Ribble Valley Borough Council
Housing & Development Control

Application no: **3/2022/0500**

Address: **Land to the south of Chatburn Old Road Chatburn**

Proposal: **Technical Details Consent for residential development of upto 9 dwellings following Permission in Principle application 3/2018/0582 and appeal APP/T2350/W/19/3223816.**

stanton andrews architects	
	44 york street clitheroe BB7 2DL t. 01200 444490 e. mail@stantonandrews.co.uk w. stantonandrews.co.uk	
project moorend	project number 1903	drawing number PL 52
name site sections - additional	scale 1 to 200 @ A1	date august 2020
status planning	revision A

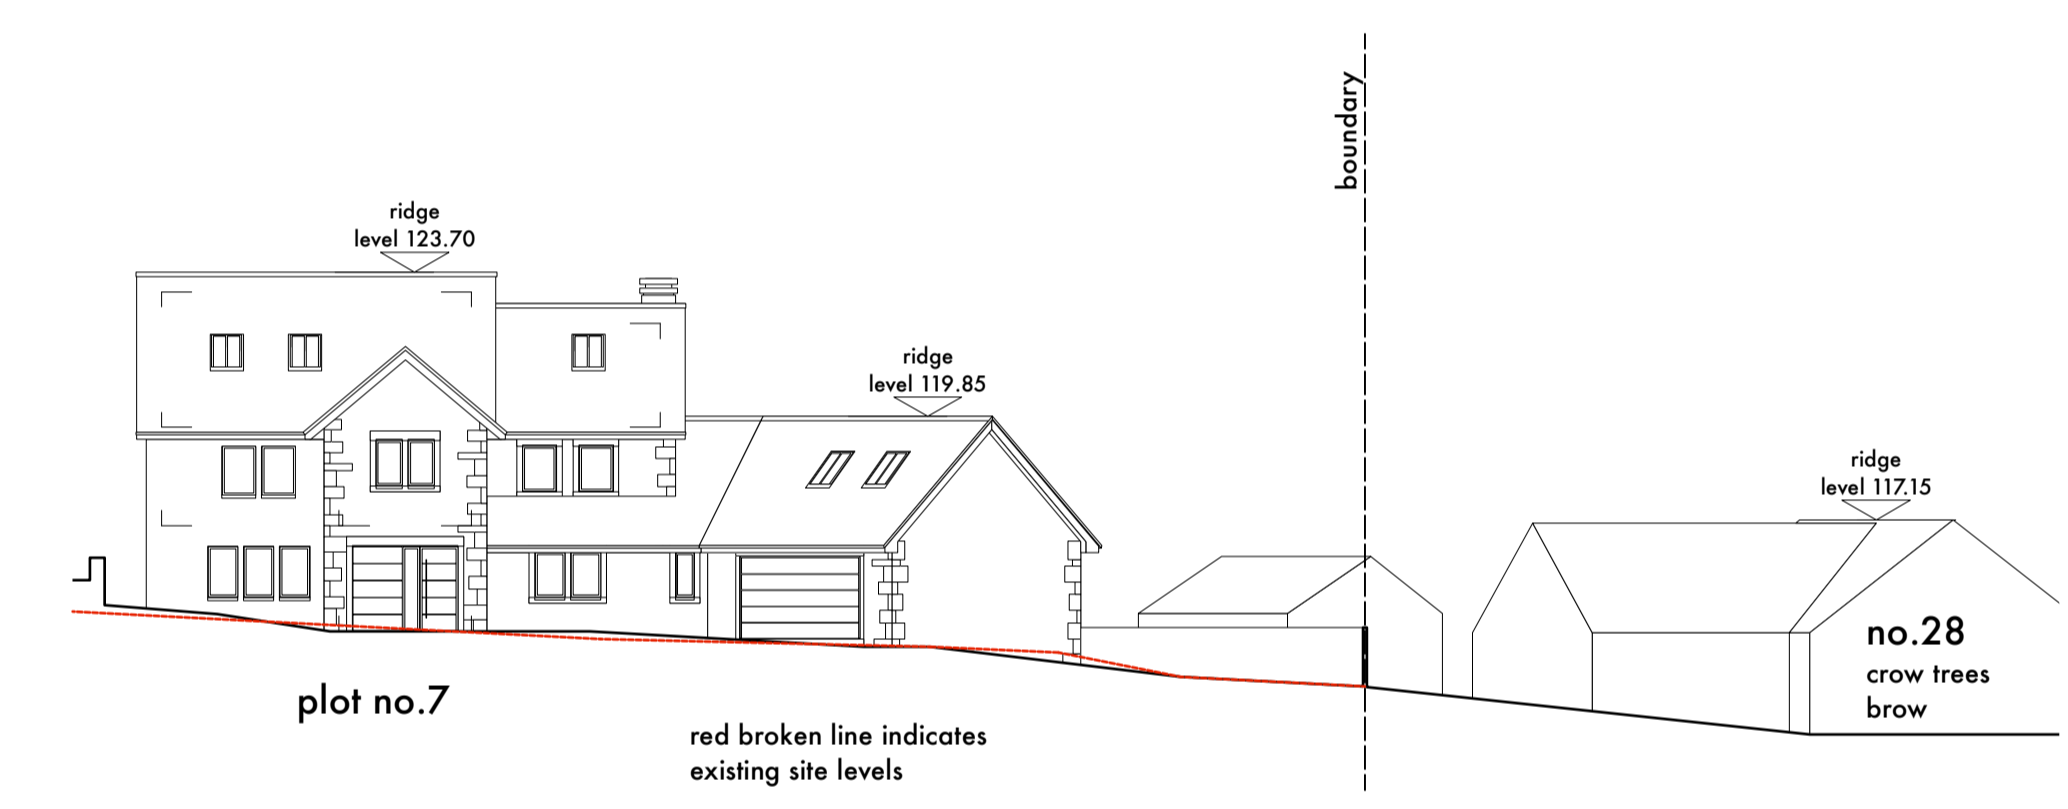
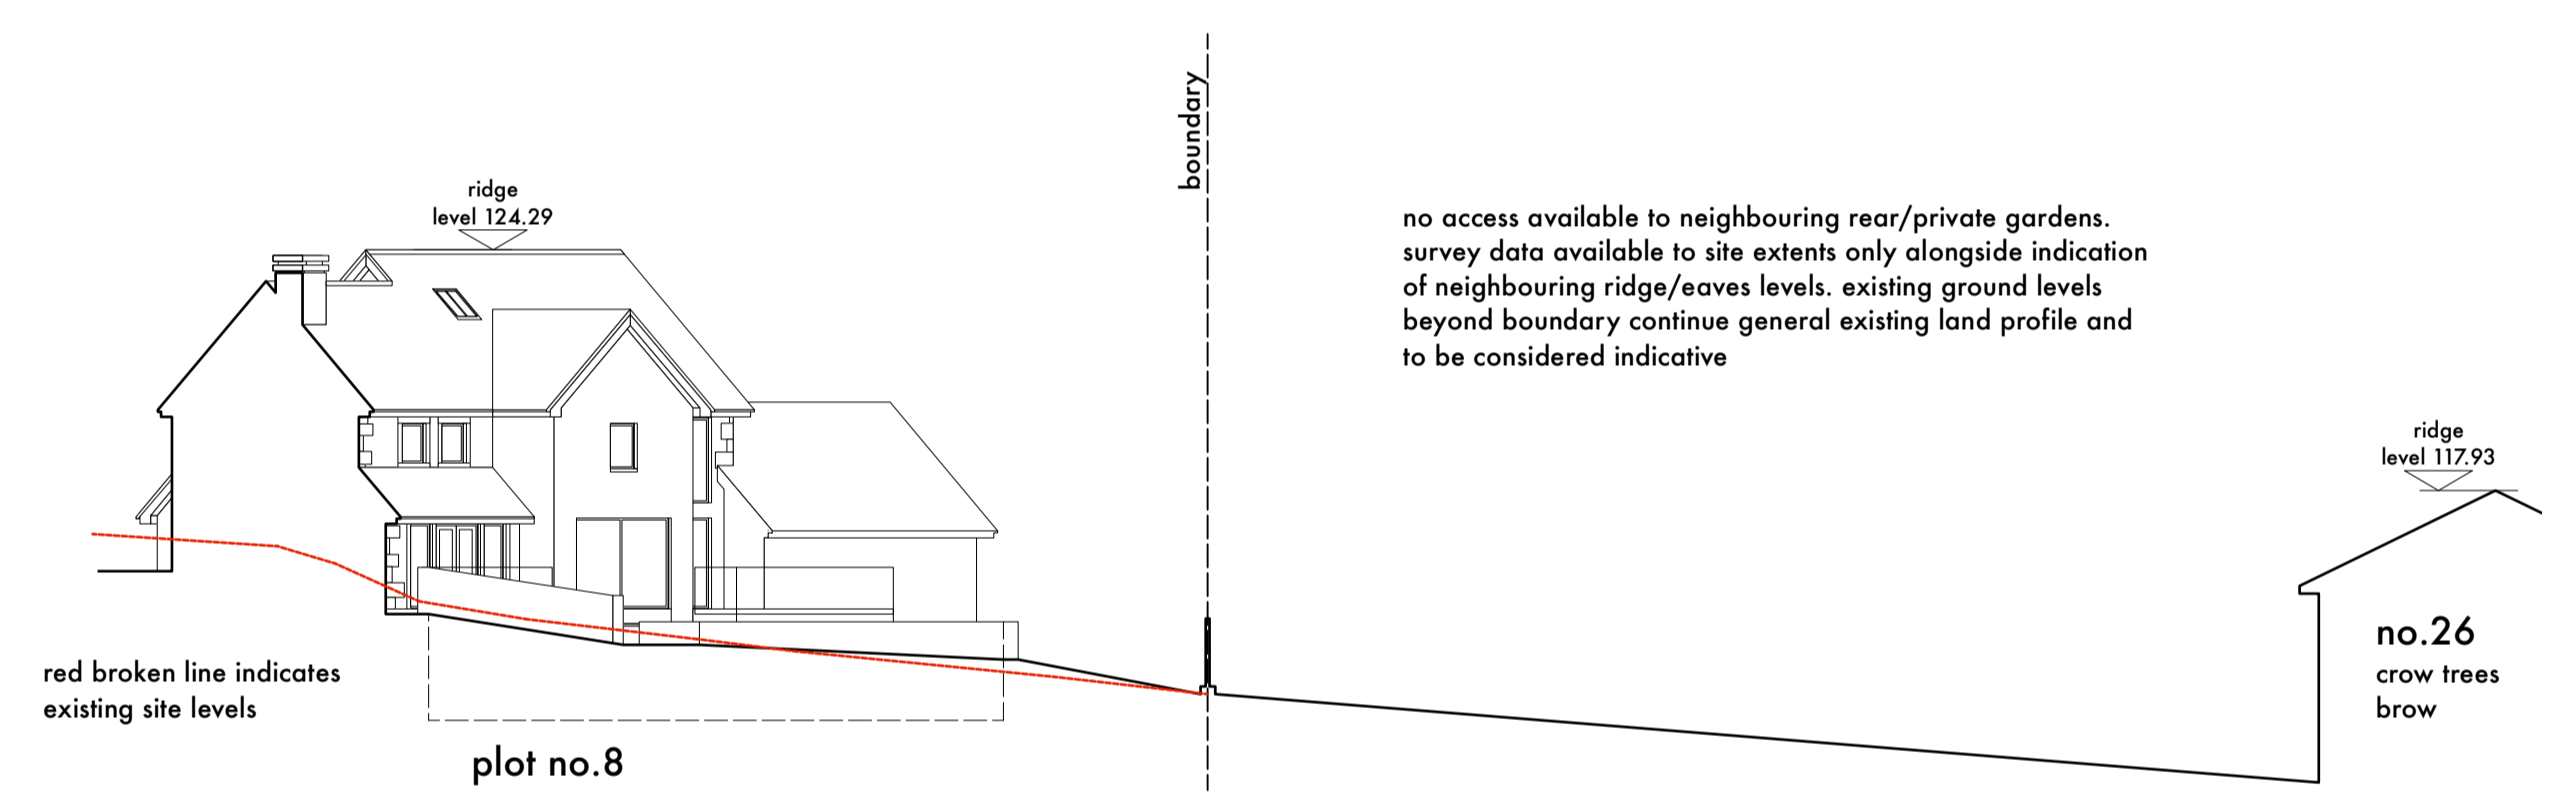
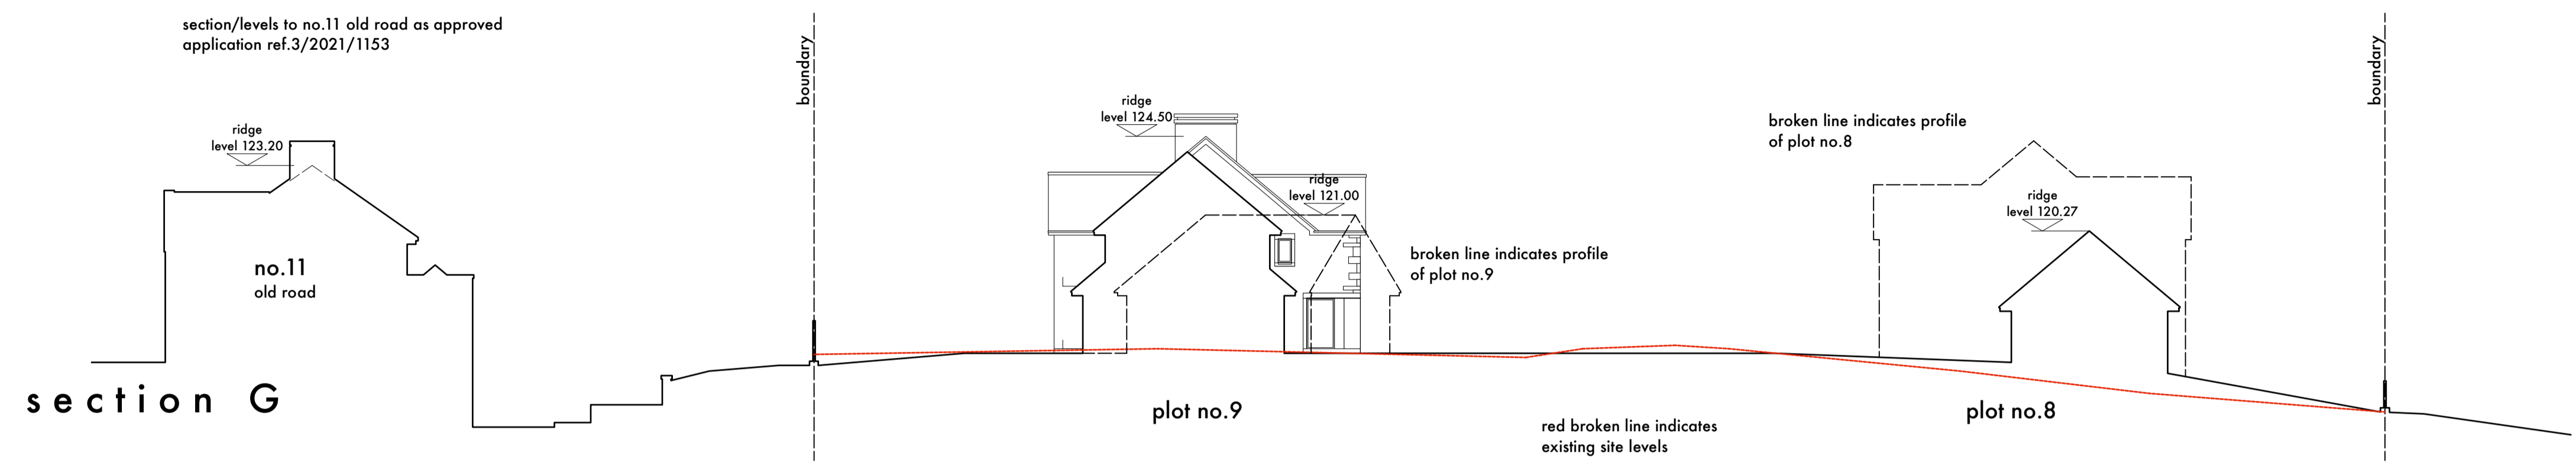
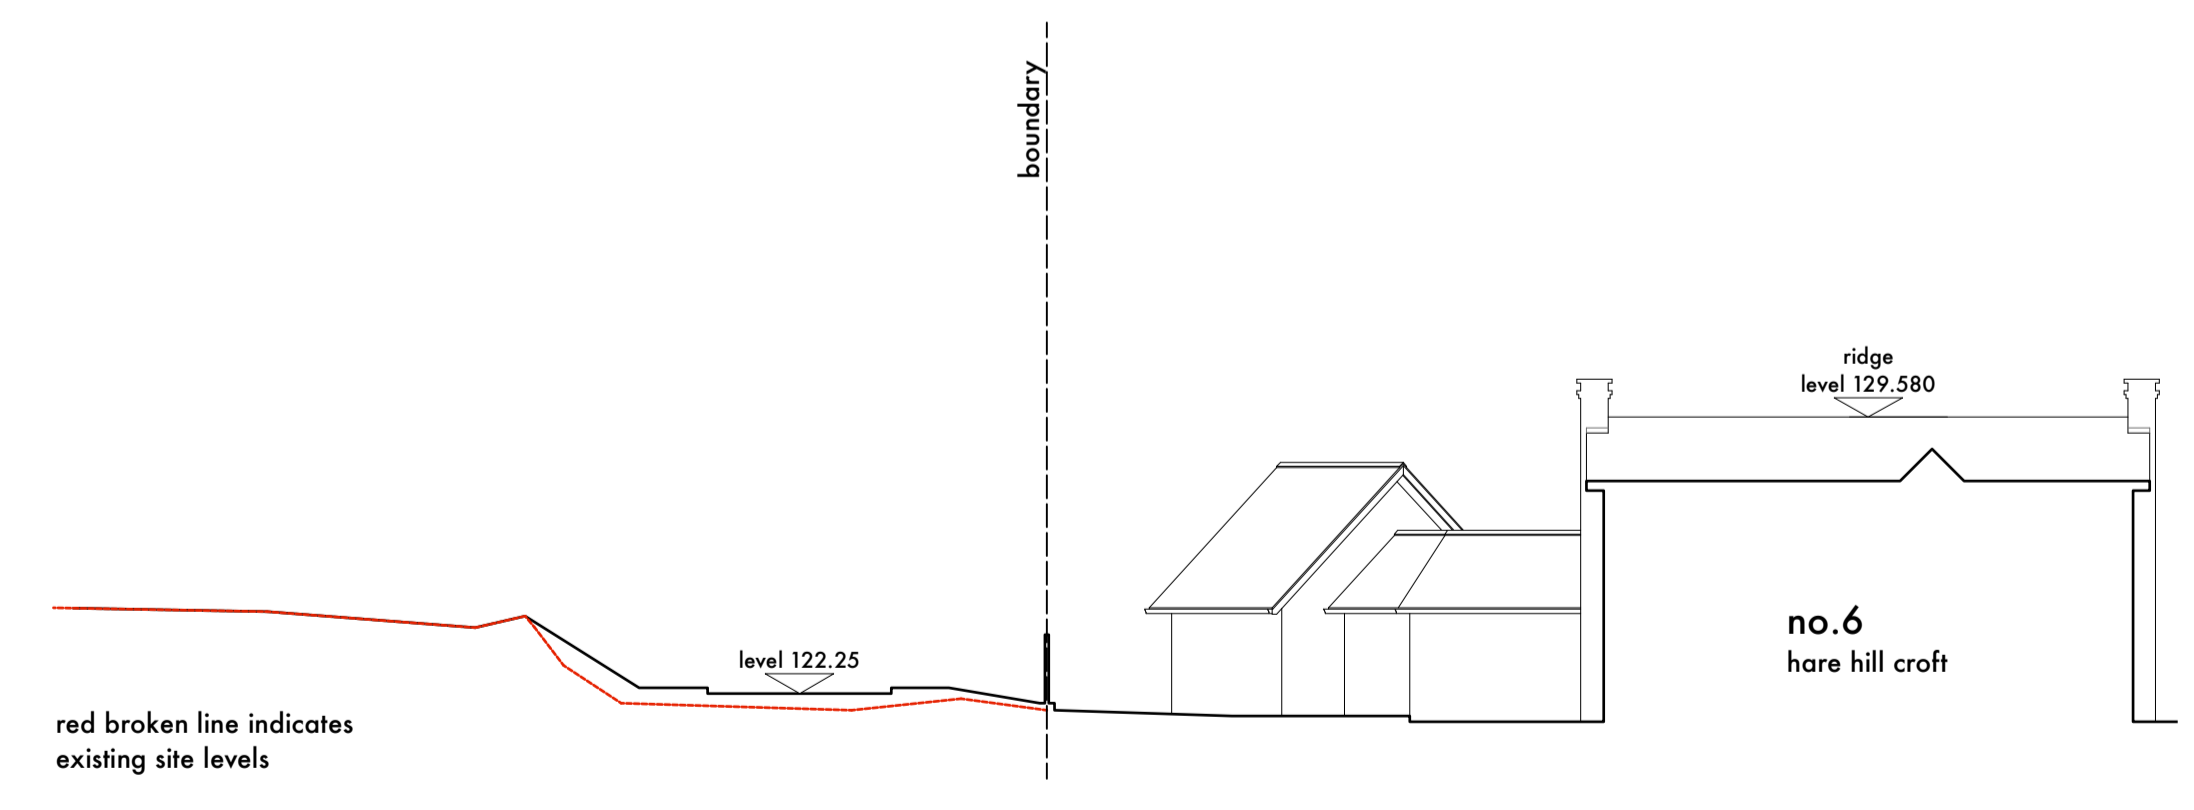
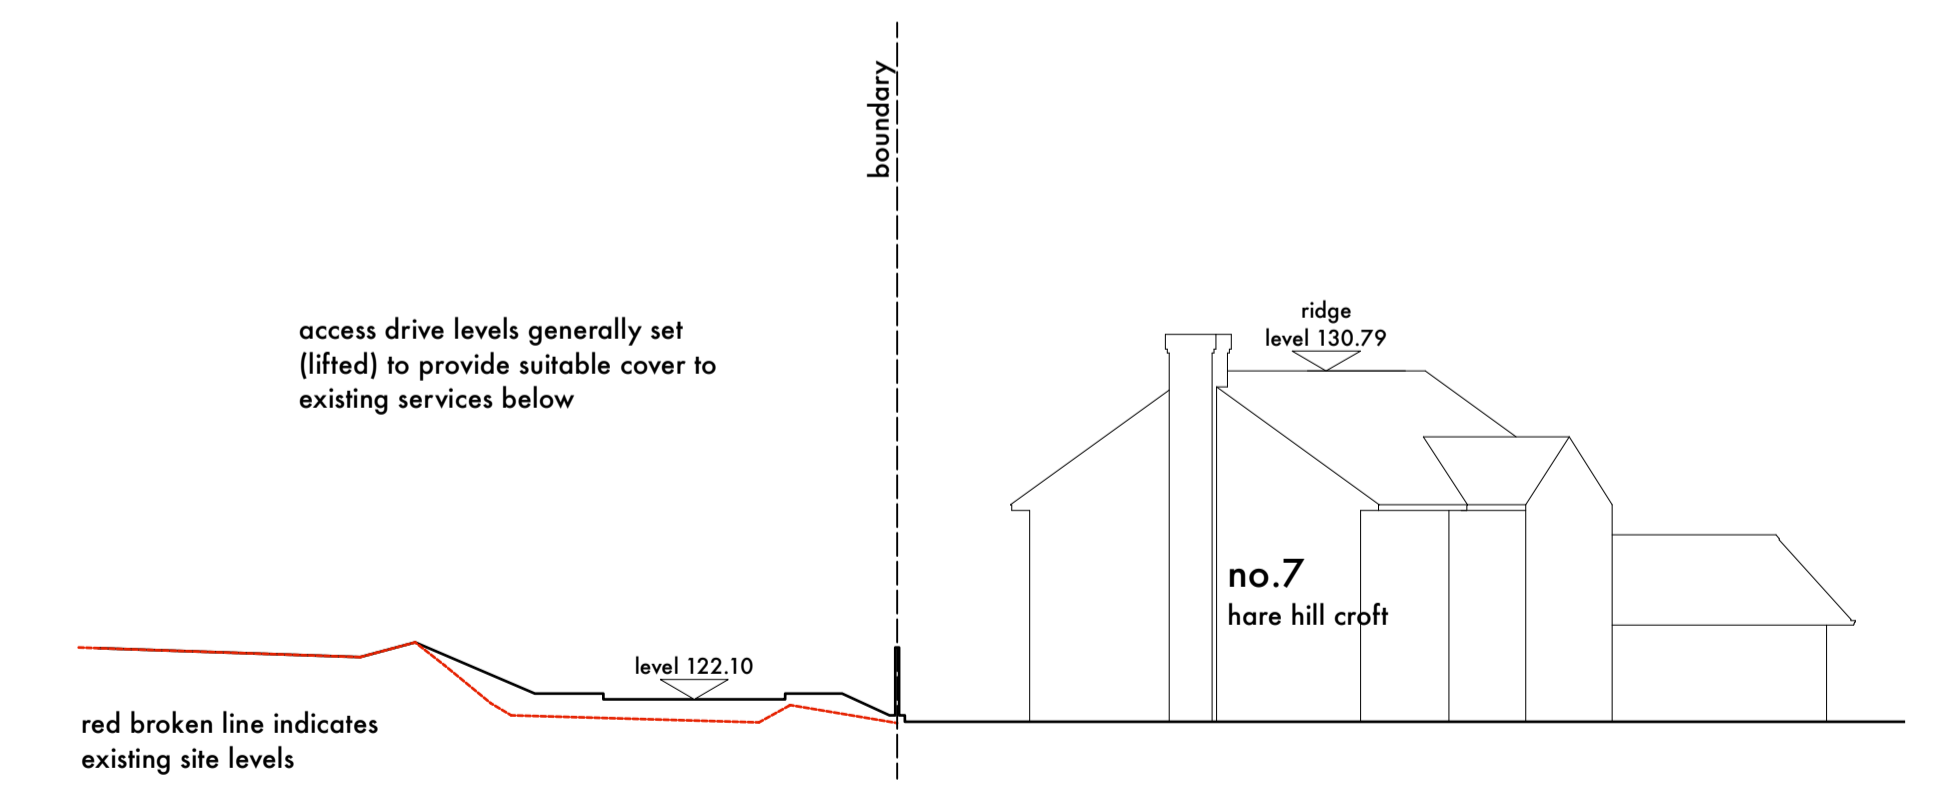
The LHA have also reviewed the site section and long section drawings of the access and the internal carriageway and are satisfied that the gradient throughout the site complies with the LHAs guidance.
